# CITY OF ALBUQUERQUE

**RE: Sedona West  
9330 Eagle Ranch Rd NW  
30-Day Temporary C.O. - Accepted  
Engineer's Certification Date: 12/17/2025  
Engineer's Stamp Date: 10/19/2022  
Hydrology File: C13D001  
Case # HYDR-2025-00448**

**PHASE I DRAINAGE AND GRADING CERTIFICATION**

**CG101**

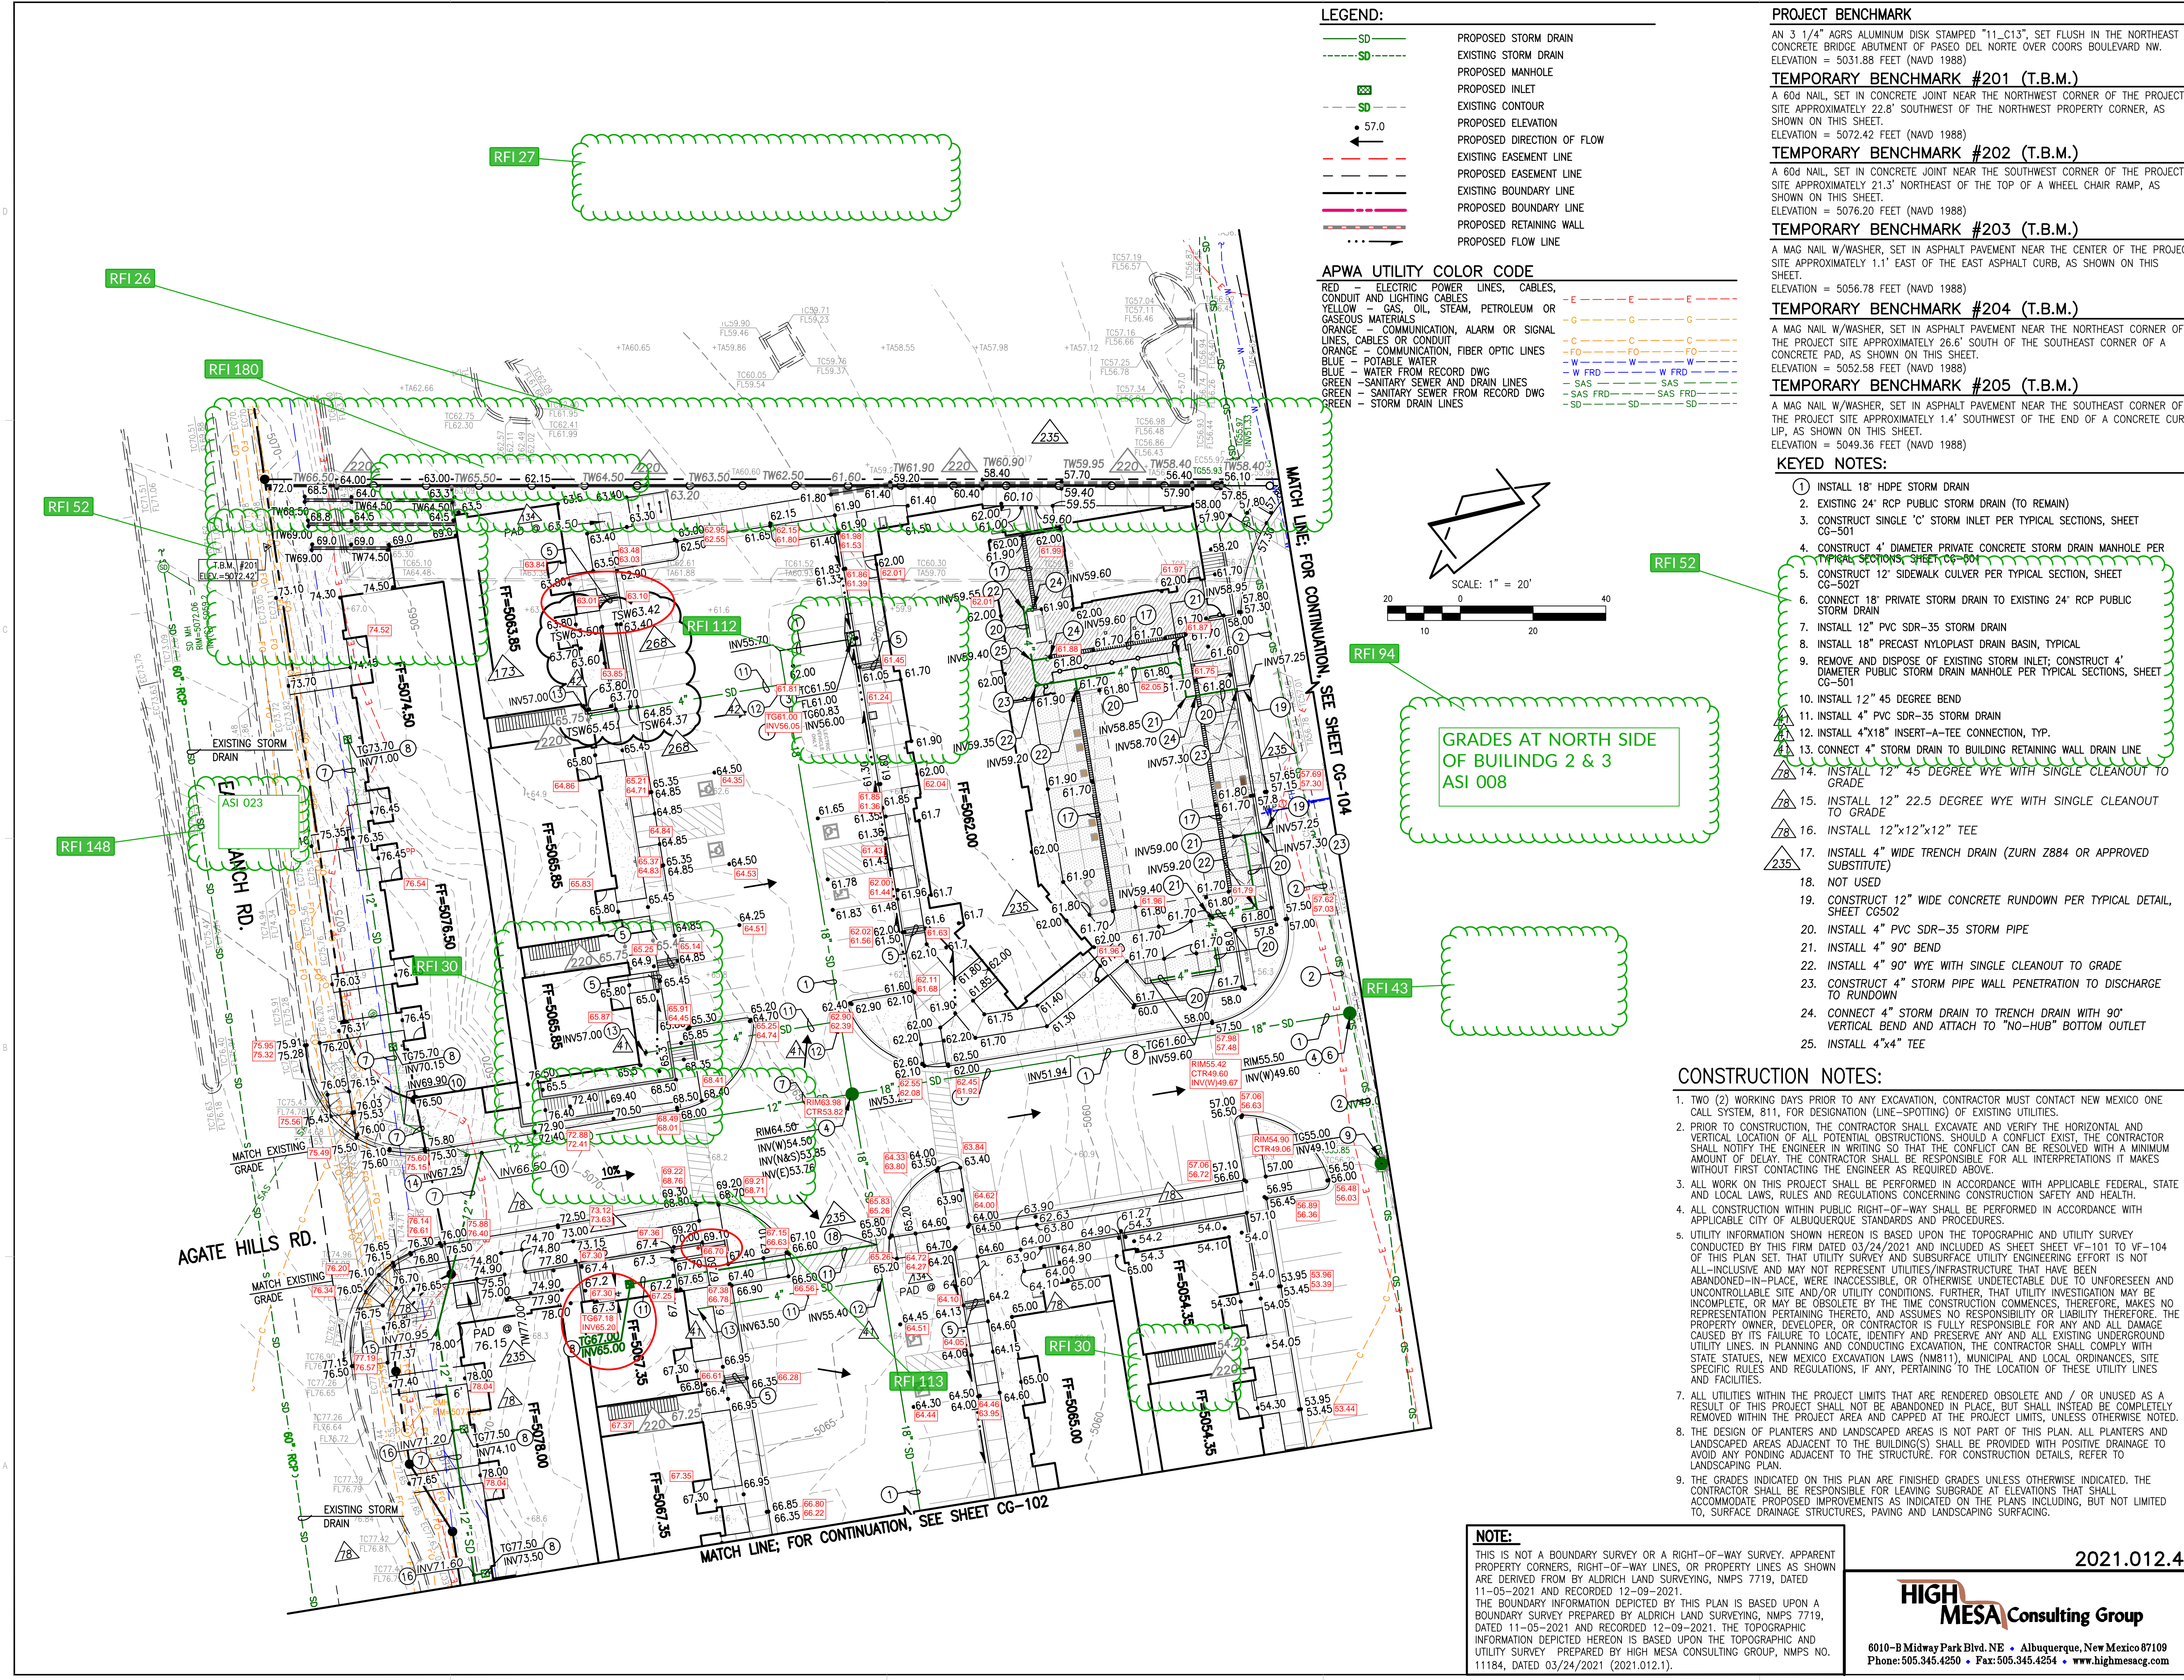
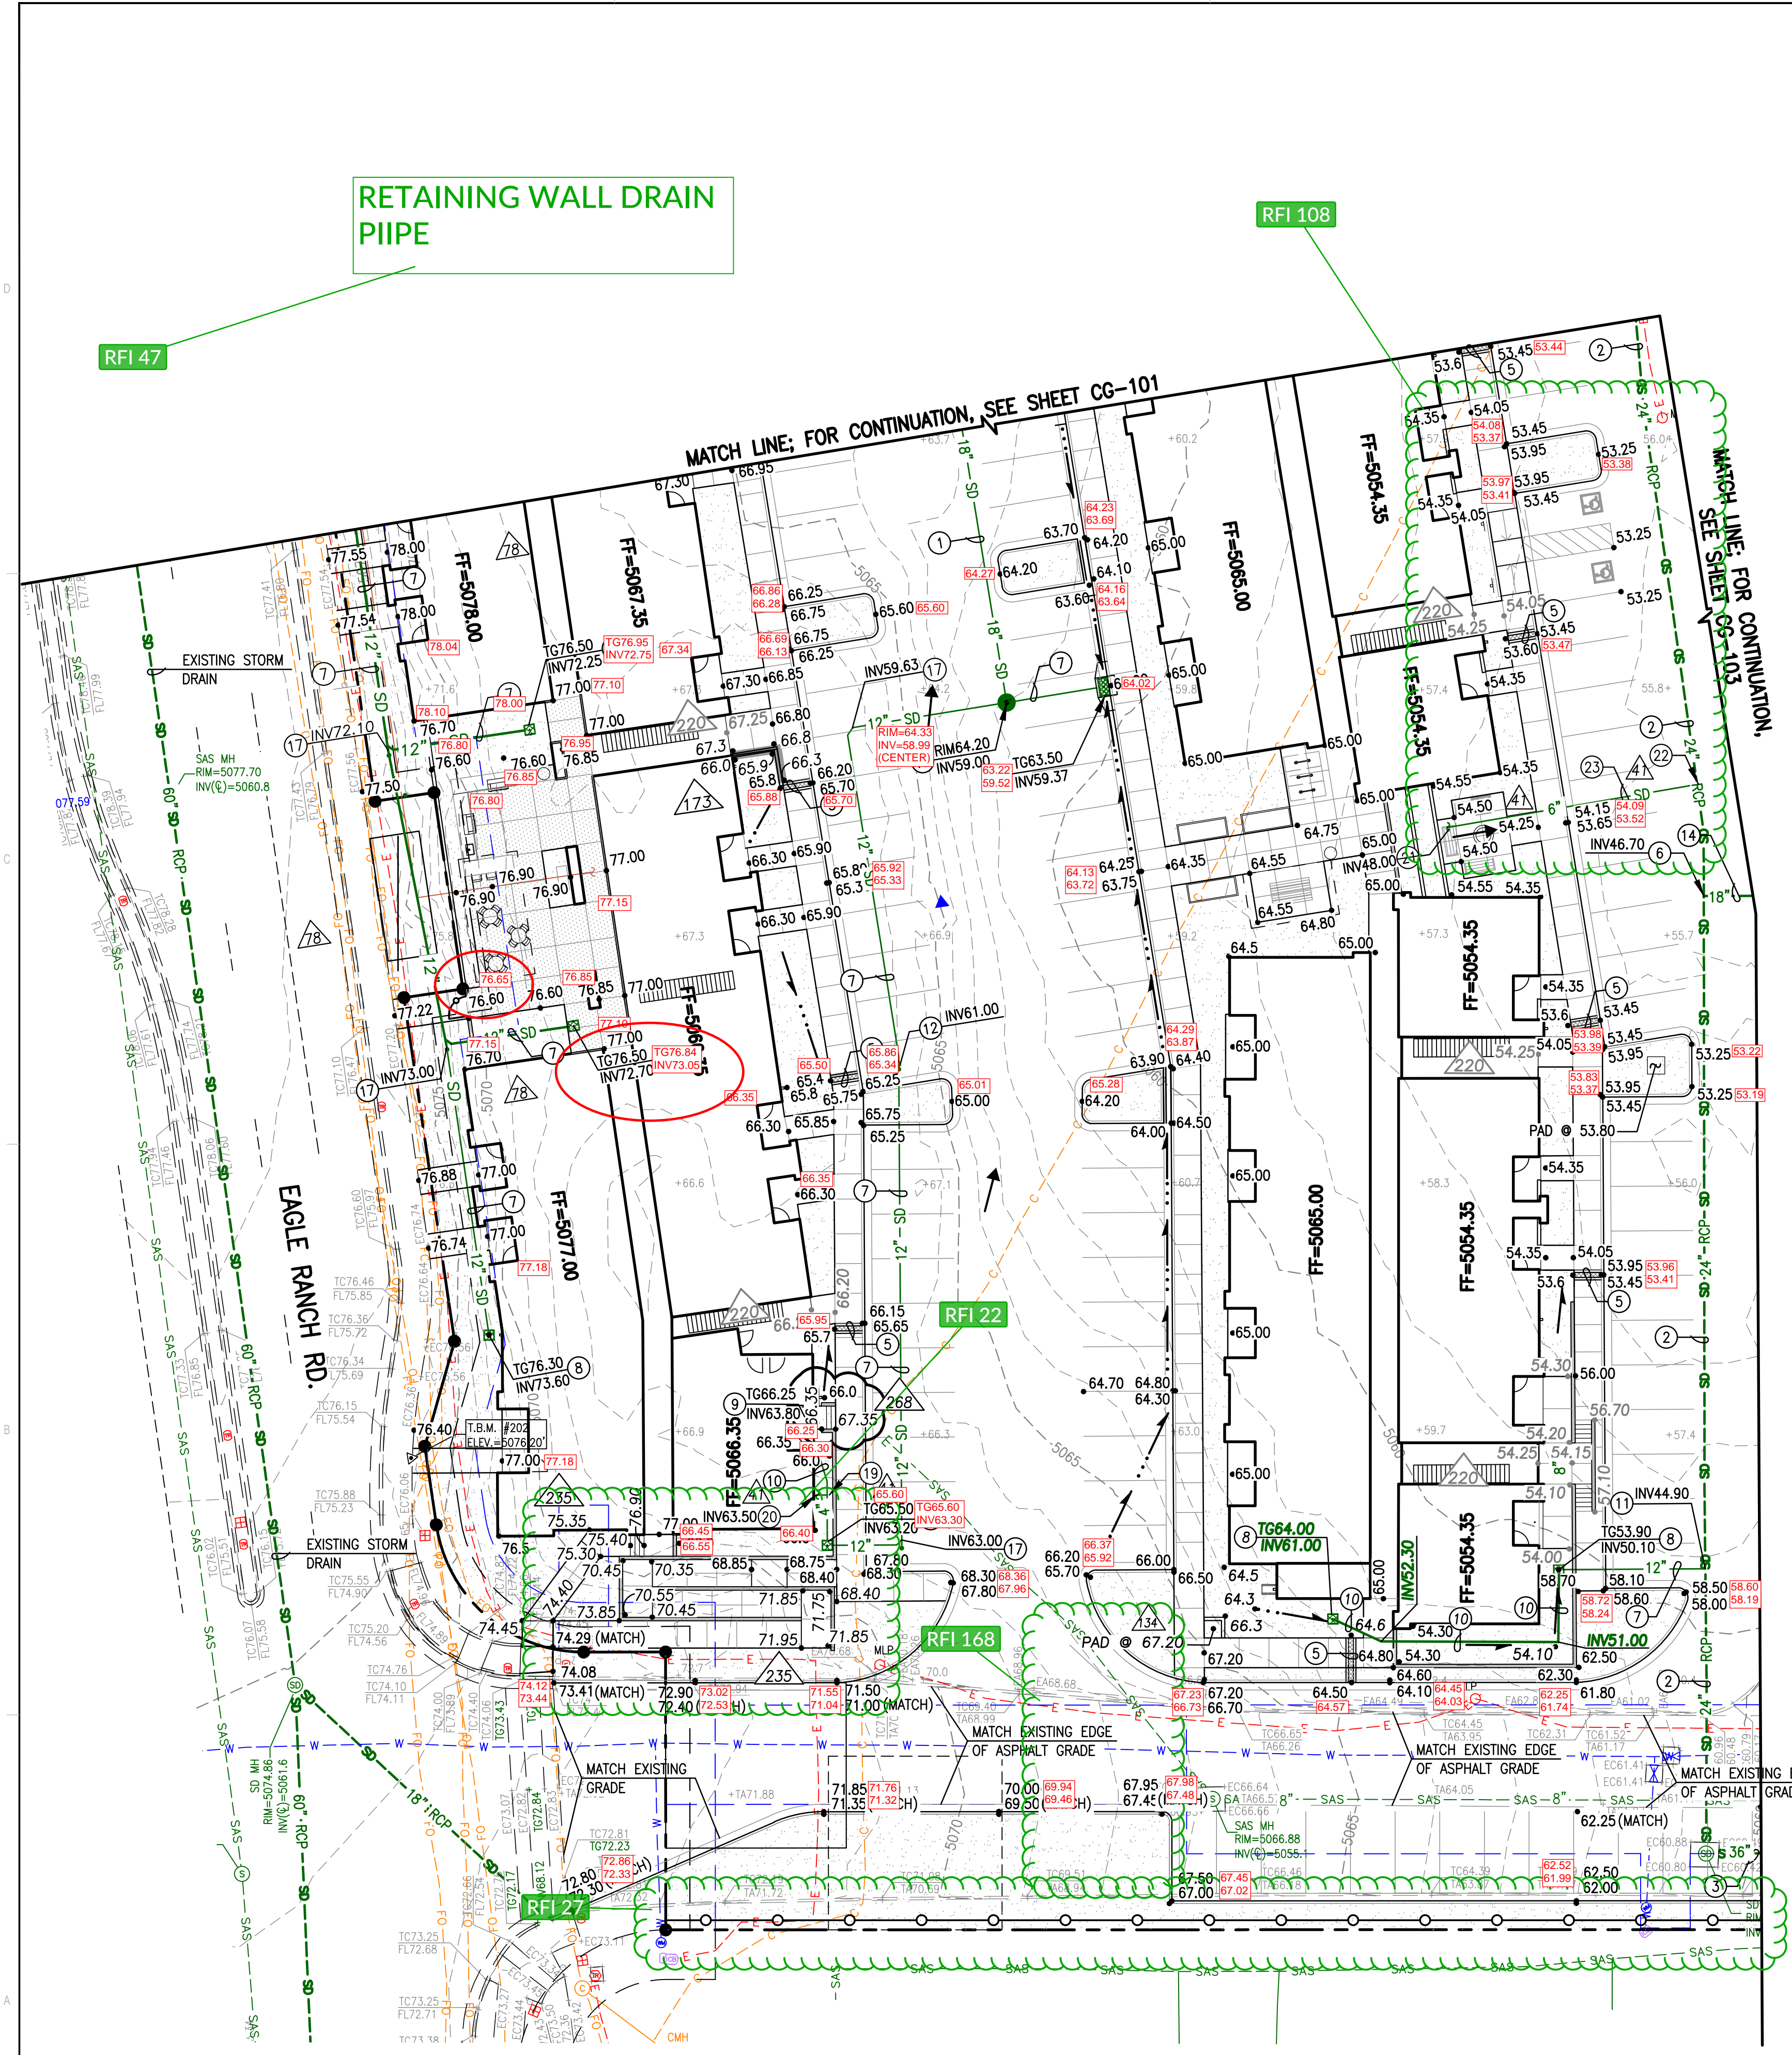
1. Bldg.1: Correct the invert elevation of the sidewalk culvert at NE corner of the building.
2. Bldg. 2: Adjust the inlet grate in the upper courtyard of the Building.
3. Bldg. 2: Adjust the grades in the depressed area between the NE corner of the building and the wall.

- 1) BUILDING 1: INLET ELEVATION OF SIDEWALK CULVERT AT NORTHEAST CORNER OF BUILDING APPEARS TO BE SLIGHTLY LOWER THAN THE OUTLET ELEVATION THAT DISCHARGE TO PARKING LOT. BOTH INVERTS ARE BELOW FINISHED FLOOR OF BUILDING, BUT ADJUSTMENT OF INLET SIDE ELEVATION WILL NEED TO BE ADJUSTED TO PROVIDE POSITIVE DRAINAGE AWAY FROM BUILDING
- 2) BUILDING 2: INLET GRATE IN UPPER COURTYARD OF BUILDING IS TWO-TENTHS HIGHER THAN ADJACENT PAVED GRADES. INLET ADJUSTMENT NECESSARY TO FACILITATE POSITIVE DRAINAGE OF COURTYARD.
- 3) BUILDING 2: DEPRESSED AREA BETWEEN NORTHEAST CORNER OF BUILDING AND ADJACENT RETAINING WALL HAS A FINISHED GRADE ELEVATION THAT IS SEVERAL INCHES LOWER THAN AN AREA DRAIN INLET. FINISHED GRADE IN THAT AREA MUST BE RAISED FOR POSITIVE DRAINAGE TO THE INLET.

Please resubmit for a request for permanent release of Certificate of Occupancy once the above items are complete.
